CITY OF PORTLAND, MAINE

July 22, 2015

Project Name: **Bangor Savings Bank Bank/Office building with two lane drive-through**
Project ID: #2015-080
Address: 20 Marginal Way CBL: 113 A 025001
Applicant: Wendy Durrah, Bangor Savings Bank
Planner: Jean Fraser

AE203

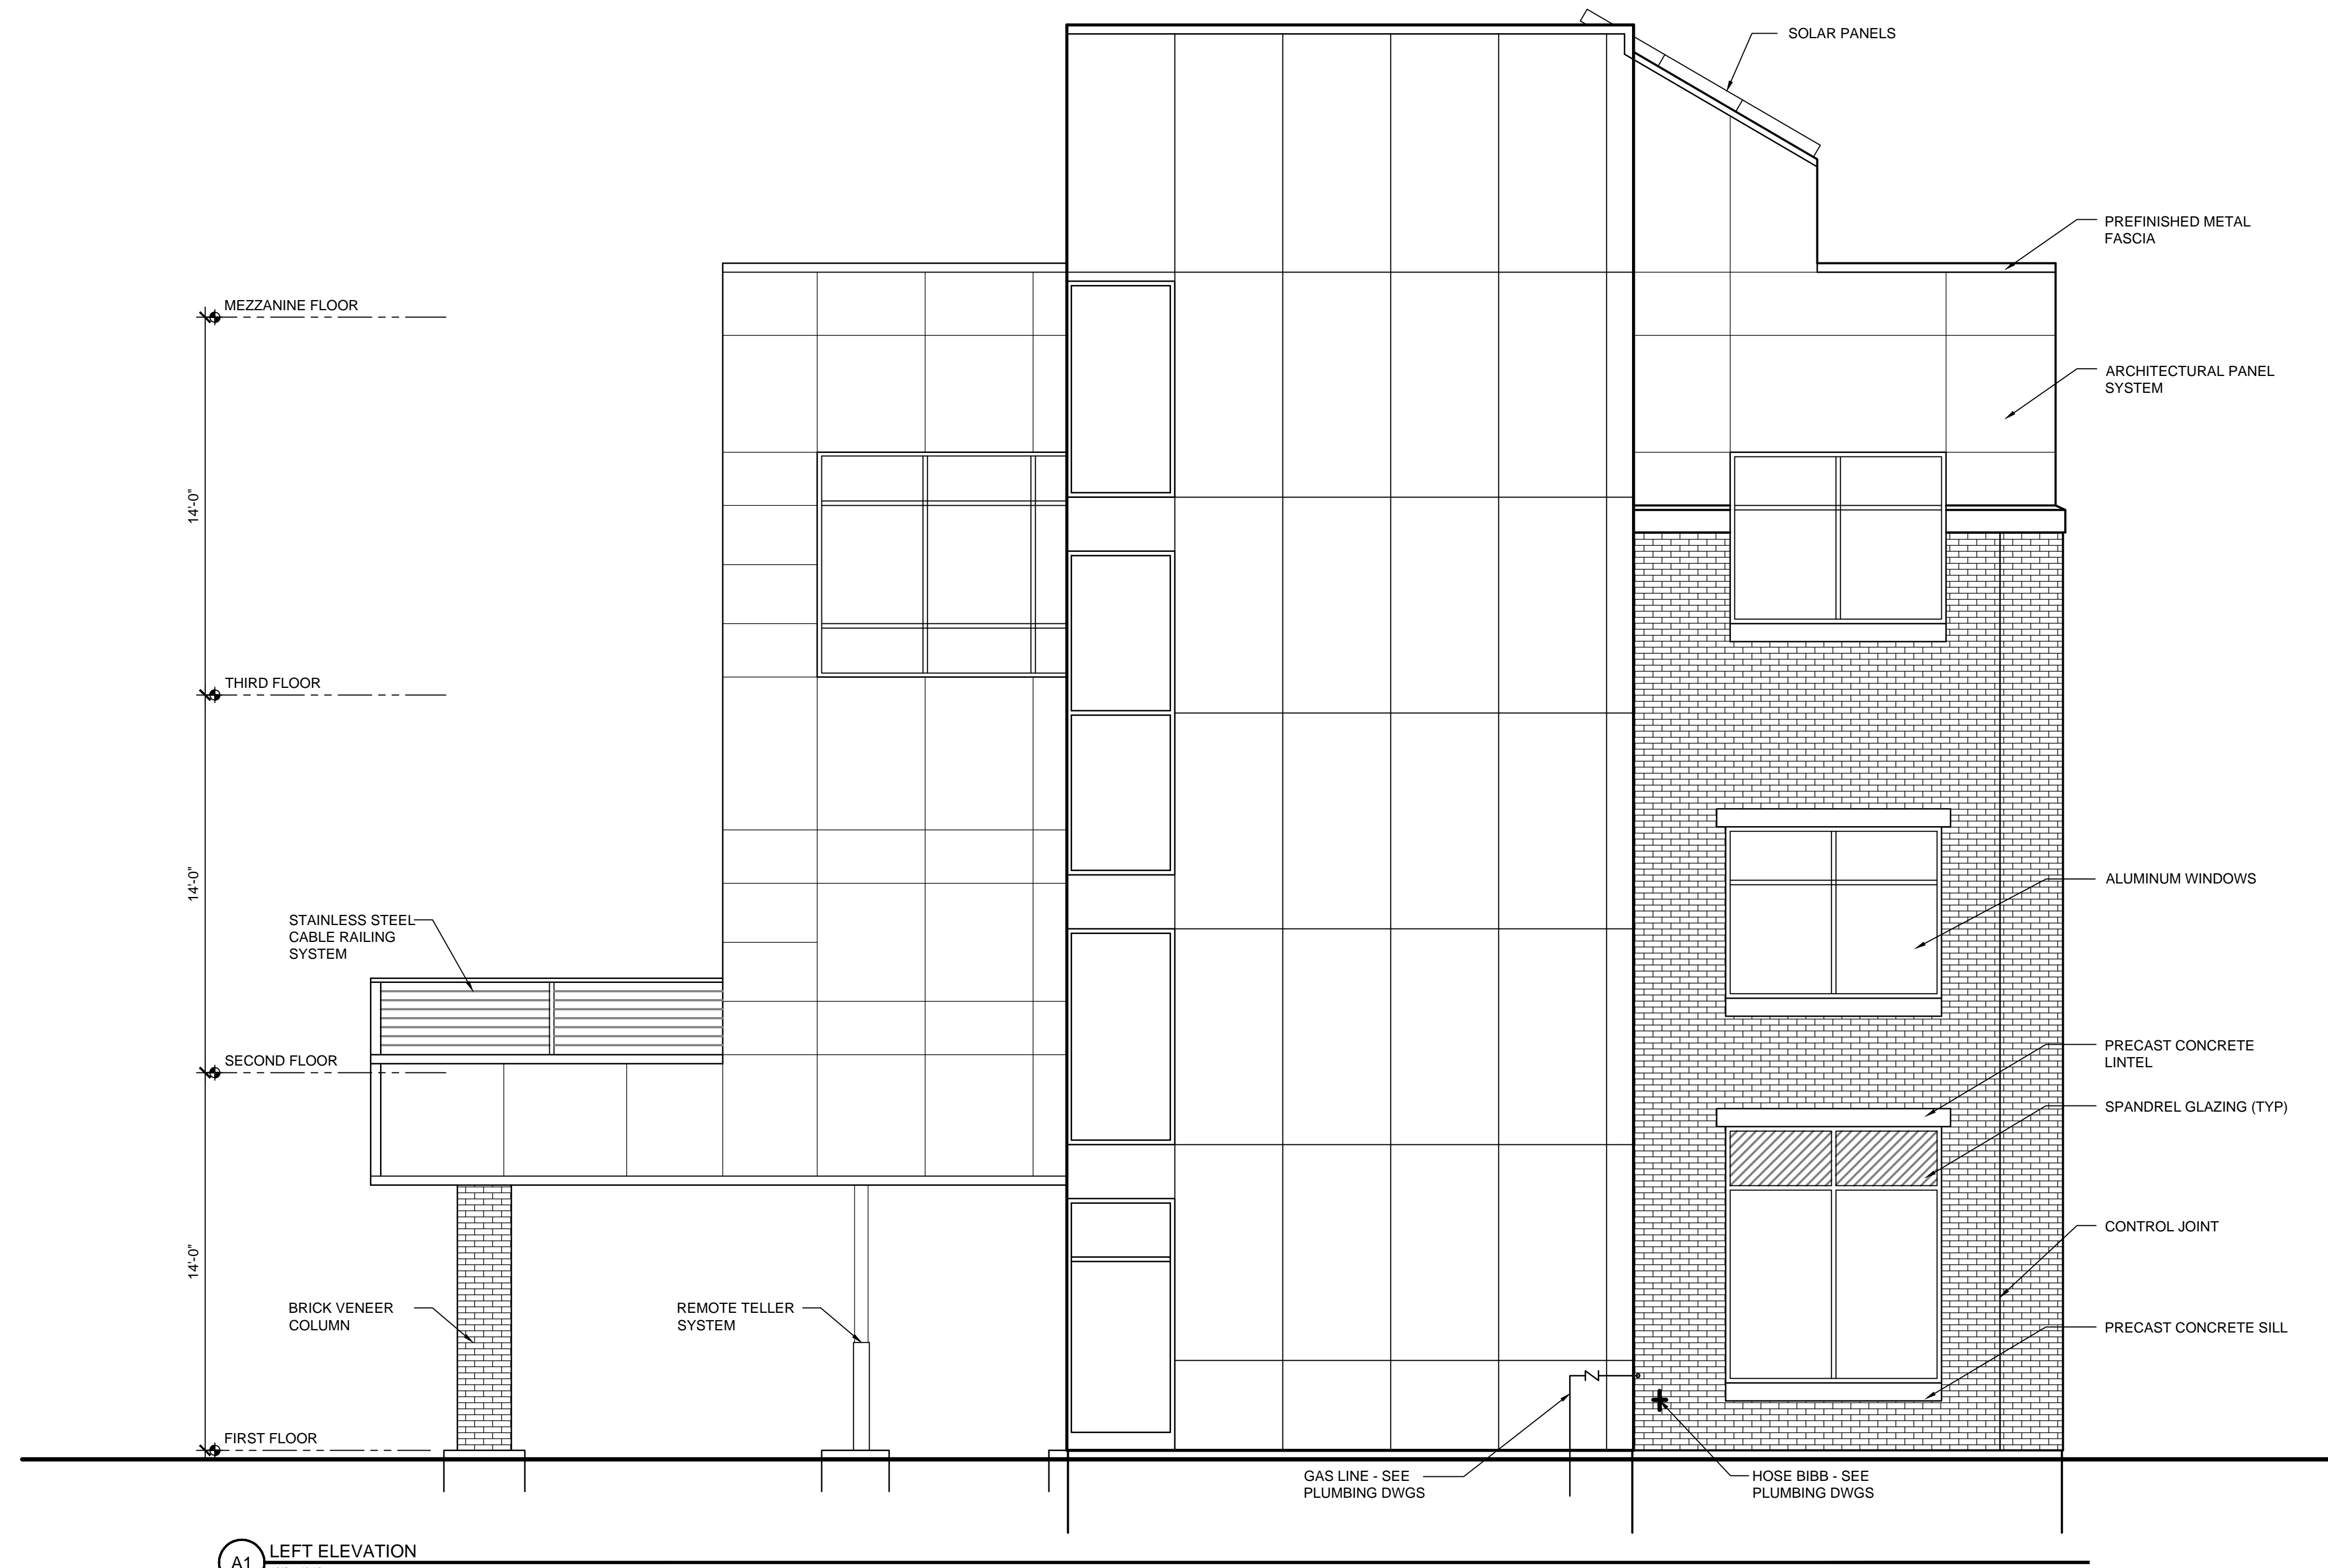
- **Proposed glass has a VLT of .56 which is lower than the allowed .7. A sample is required** before staff can assess whether the transparency is adequate.
- **Spandrel glass (opaque) is proposed** for the upper portion of the ground floor storefront which is **not allowed by the Standard. See comments below.**

- **Proposed transparency does not meet the Standard.**
- **Spandrel glass (opaque) is proposed** for the upper portion of the ground floor storefront **which is not allowed by the Standard. Staff does not support the use of spandrel glass in this project. Staff recommends that the ground floor windows be reduced in height** (and the canopy subsequently lowered) and the area where spandrel glass is proposed be eliminated. Reducing the amount of glazing will also reduce the solar gain in the façade.

- **Proposed glass has a VLT of .56 which is lower than the allowed .7. A sample is required** before staff can assess whether the transparency is adequate.
- **Proposed glass has a green tint** which is not allowed by the Standard. **Glazing should look clear. A sample is required** before staff can assess whether the color is adequate.
- **Spandrel glass (opaque) is proposed** for the upper portion of the ground floor storefront **which is not allowed by the Standard. See comments above.**

- ii. That the Planning Board has established that the maximum level of parking is 24 parking spaces; and
- iii. That the applicant shall reconsider the window design, including transparency, color, and size, in consultation with the City's Urban Designer, to meet the intent of the B-7 Design Principles and Standards. The final design to be reviewed and approved by the Planning Authority prior to the issuance of a building permit; and

Drawing file: Post Approval / As approved ES101-SitePhotometric.pdf

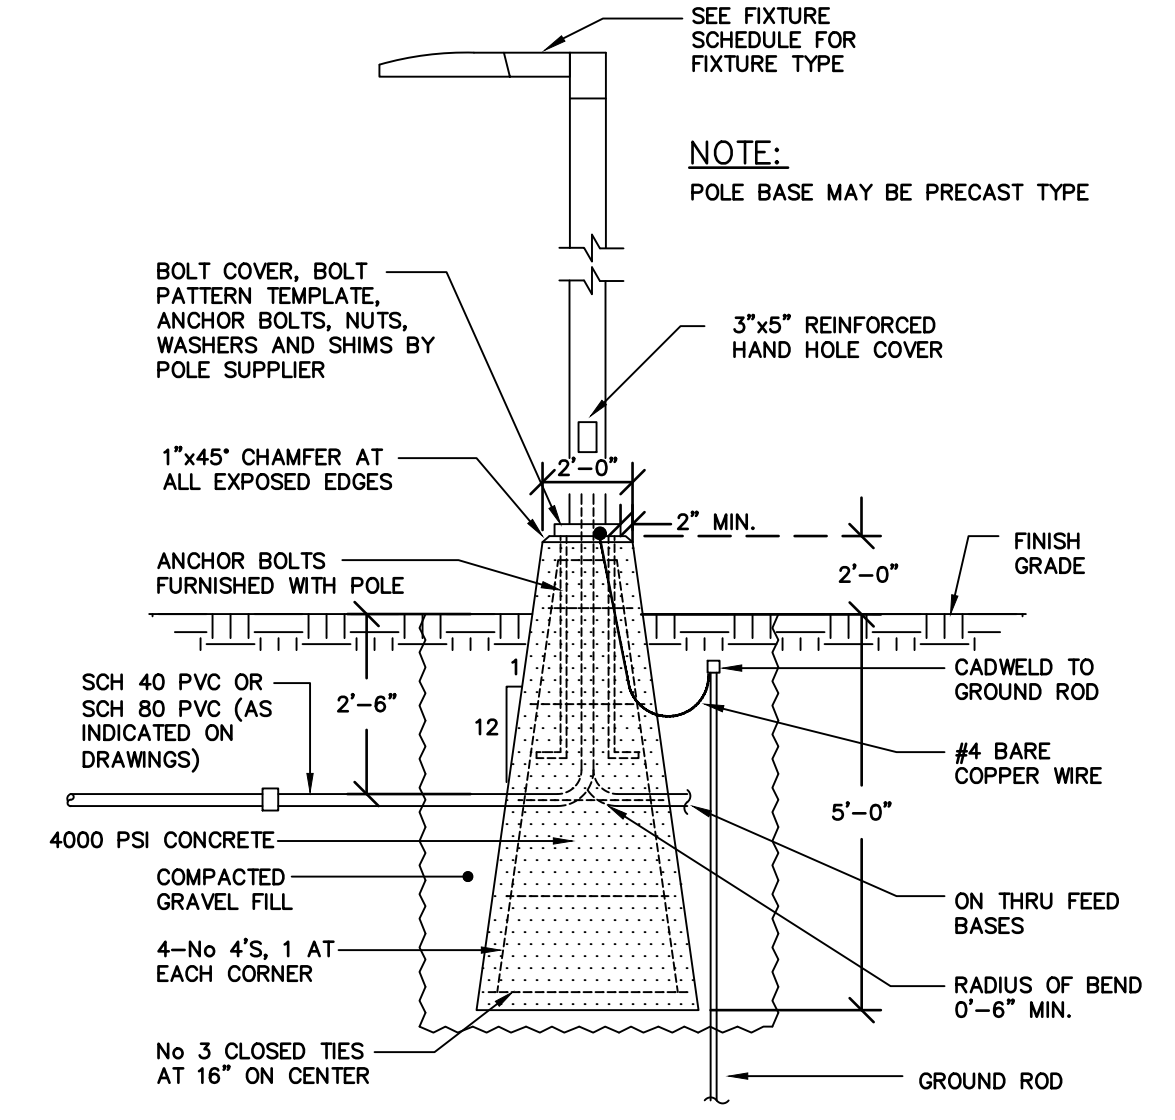
- viii. That the applicant shall submit, for review and approval by the Planning Authority prior to the issuance of a building permit, a revised photometric plan for the rear parking lot area that includes the lighting fixture specification, reduces trespass along the eastern boundary to meet Technical Standards, and increases the lighting levels in the vicinity of the drive-through; and
